January 31, 2022

RE: 3-Bay Oil Change
5400 Menaul Blvd NE
Traffic Circulation Layout

Per the correspondence dated January 26, 2022, please find the following responses addressing the comments listed below:

ALTA / NSPS LAND TITLE SURVEY

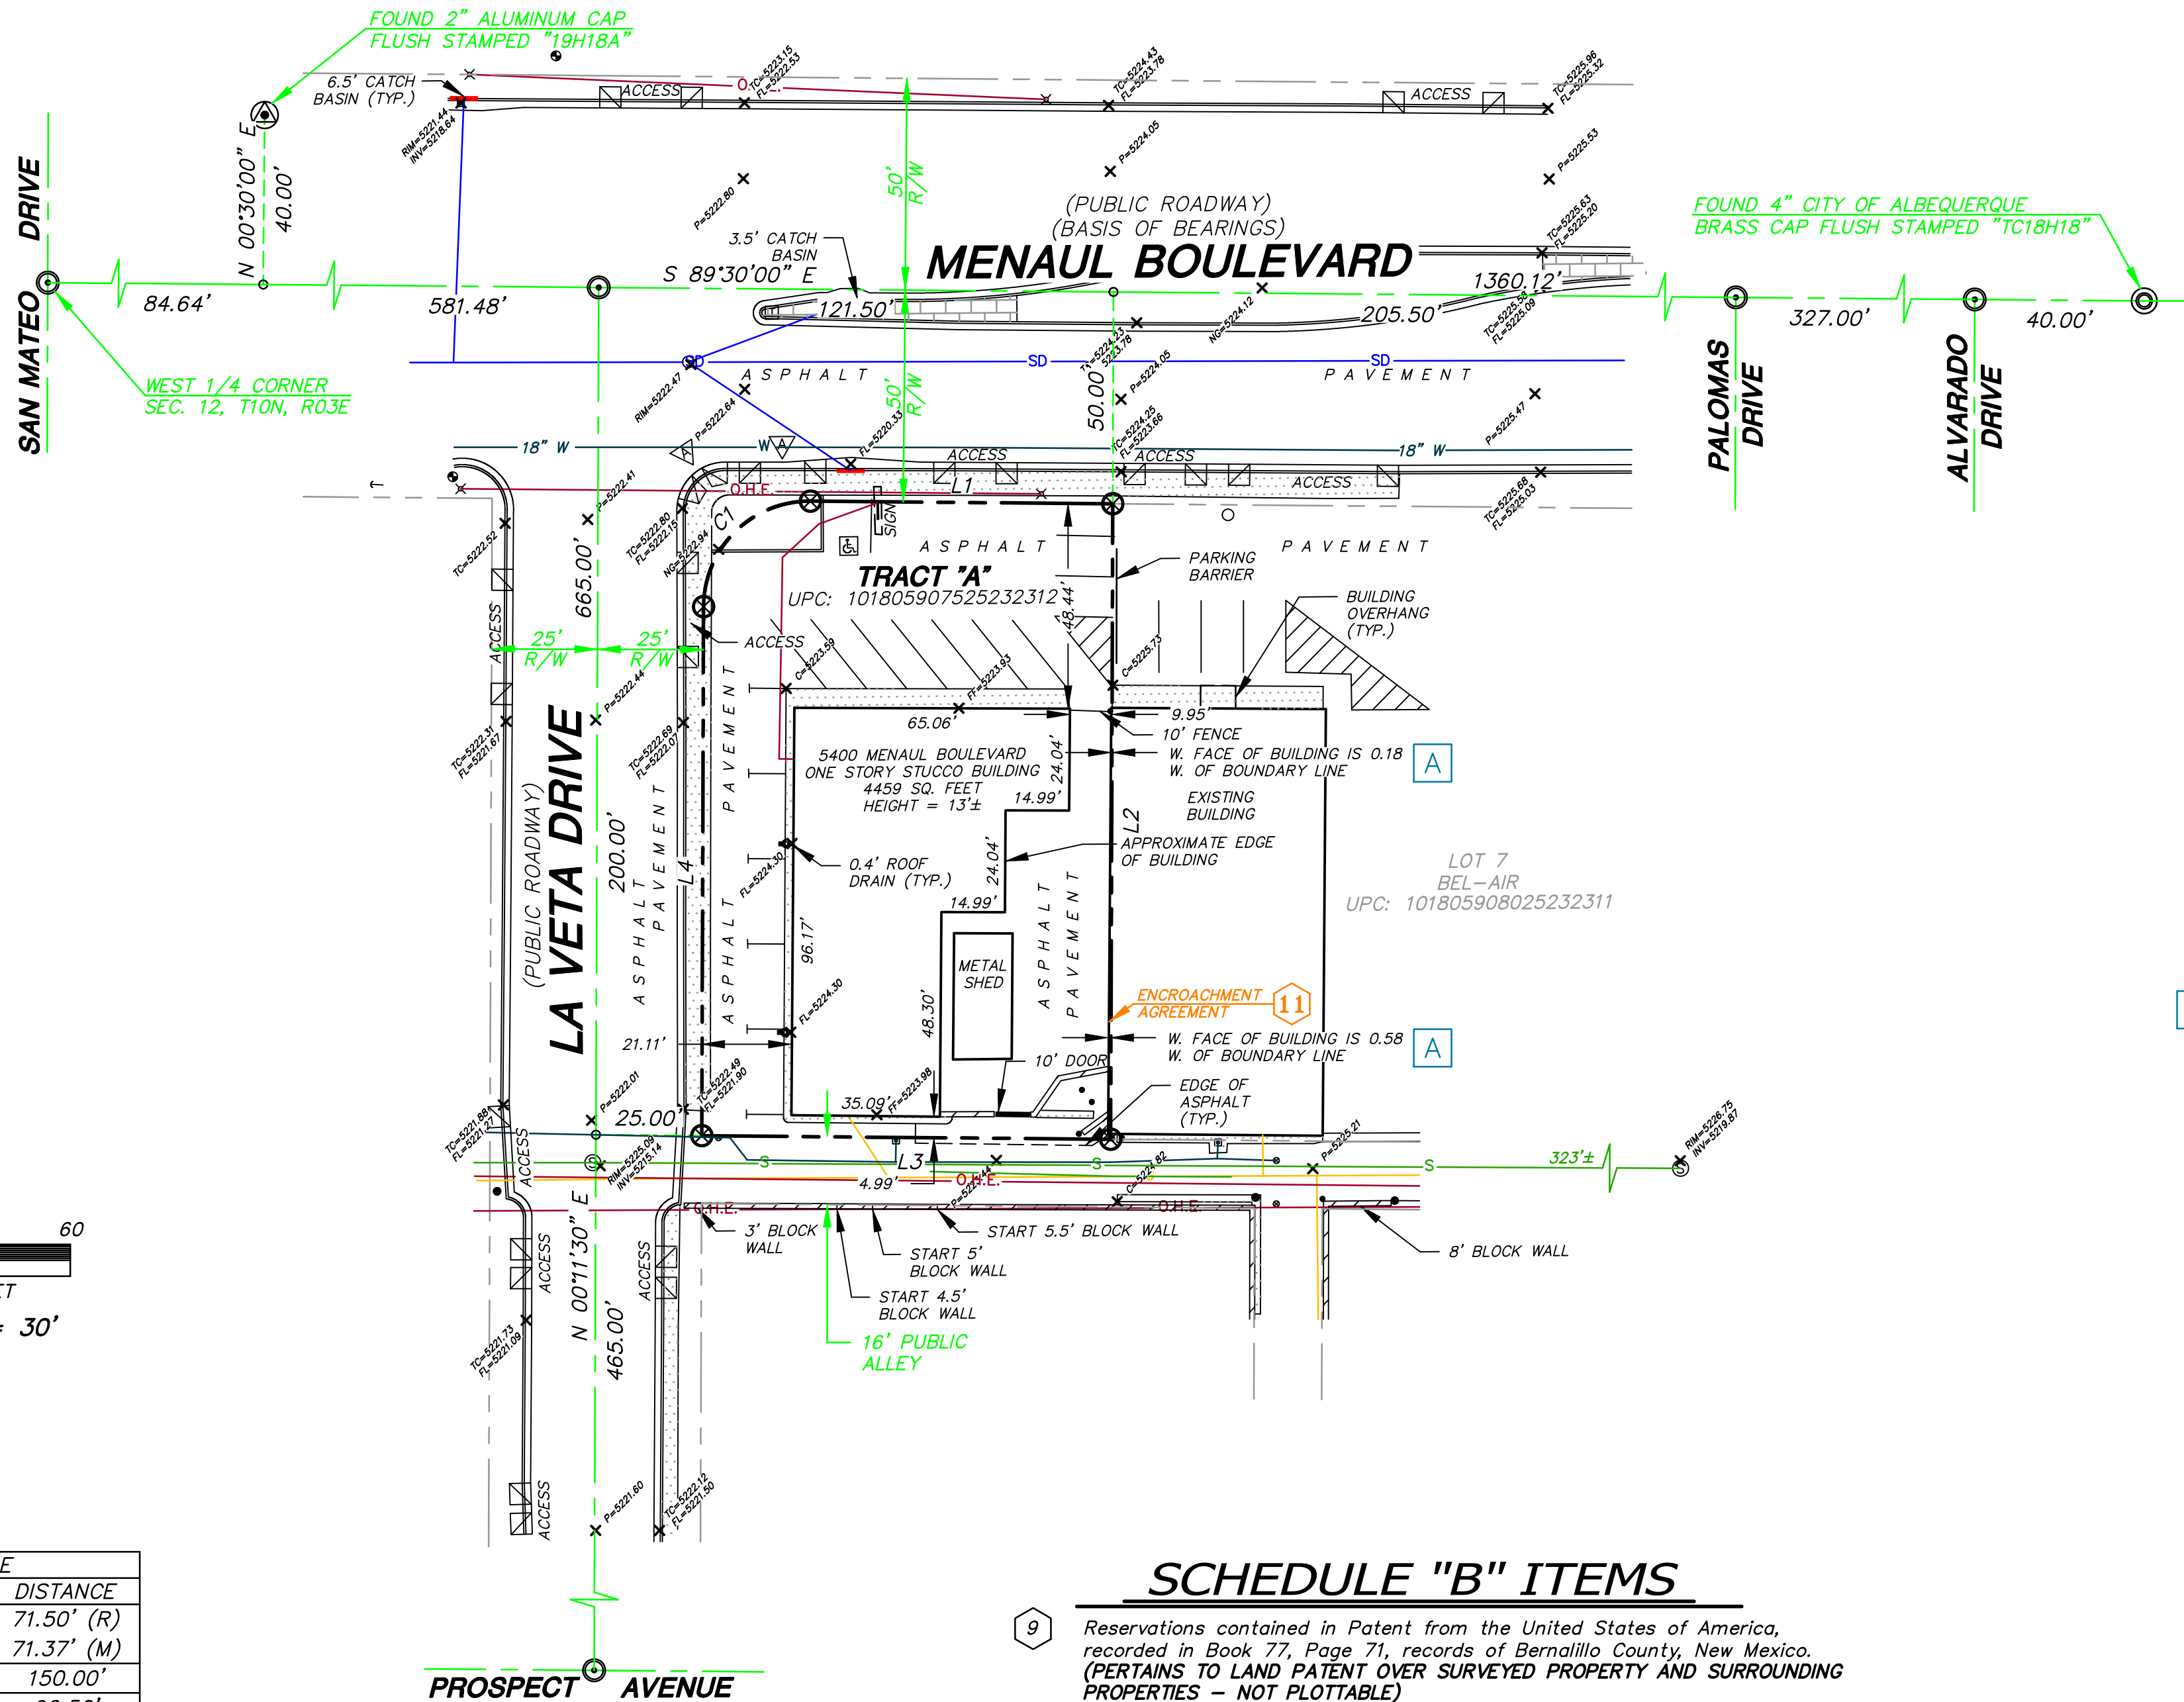
1. Provide approved Plat demonstrating adjusted lot lines. AGIS shows lots lines in a different location.
Response: See attached ALTA, plat and deed. AGIS lot lines in the immediate area seem to be off/skewed. For example Menaul Blvd. ROW is 100 ft. wide as shown on plat not 112 ft. as shown on AGIS.

MENAUL BLVD DRIVEWAY DETAIL

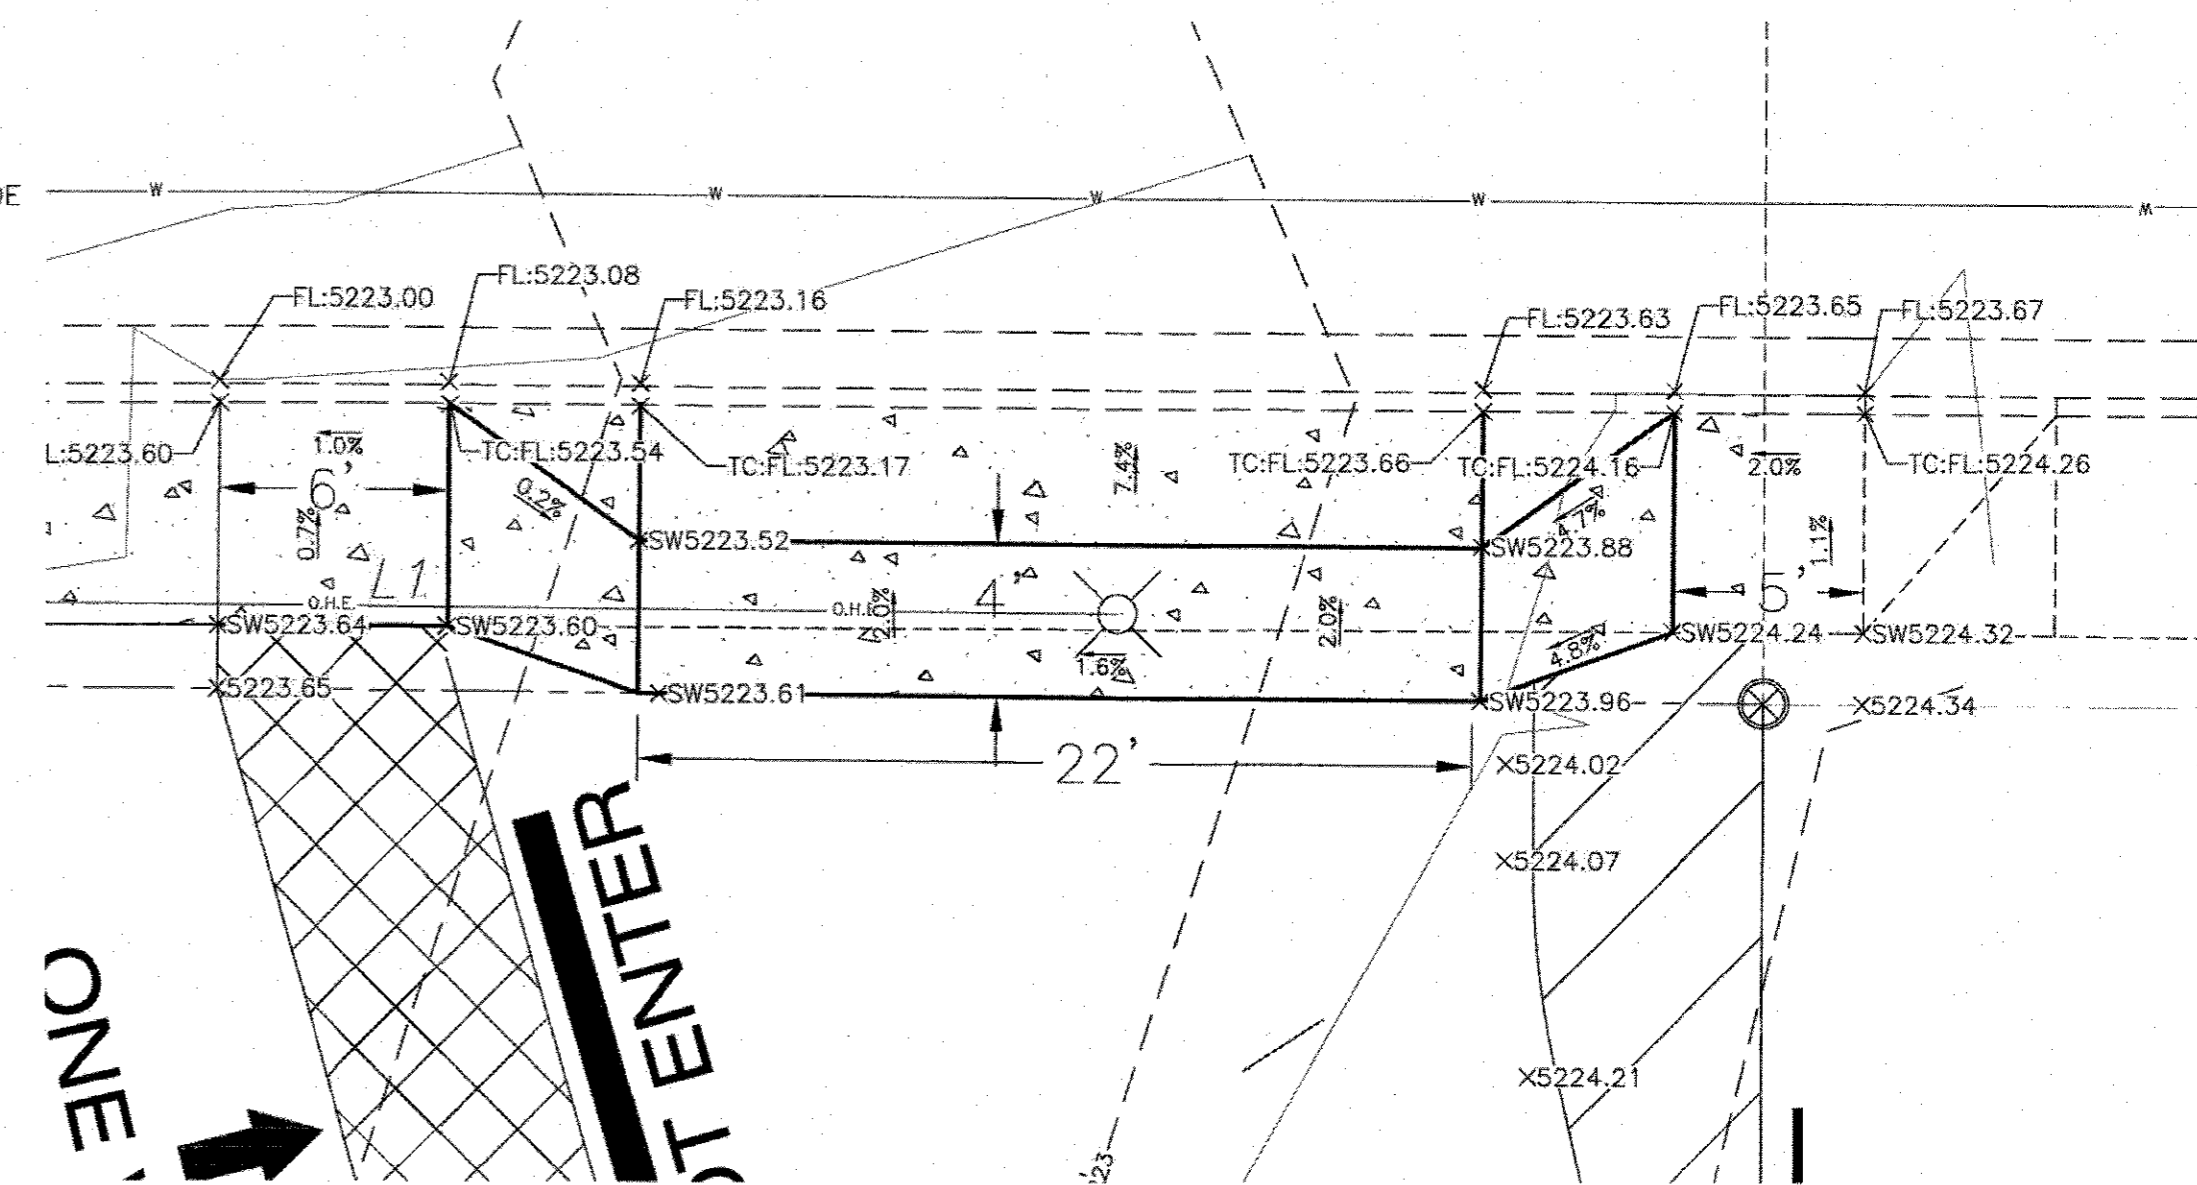
2. The new proposed 6ft ADA pedestrian pathway from Menaul appears to be a bit close to the propose driveway transition. Please verify there is not conflict between pathway and driveway transition/ramp.
Response: See attached driveway exhibit, the proposed driveway is to be built per COA standard drawings 2425A and 2425B and there is no apparent conflict with the ADA pathway.
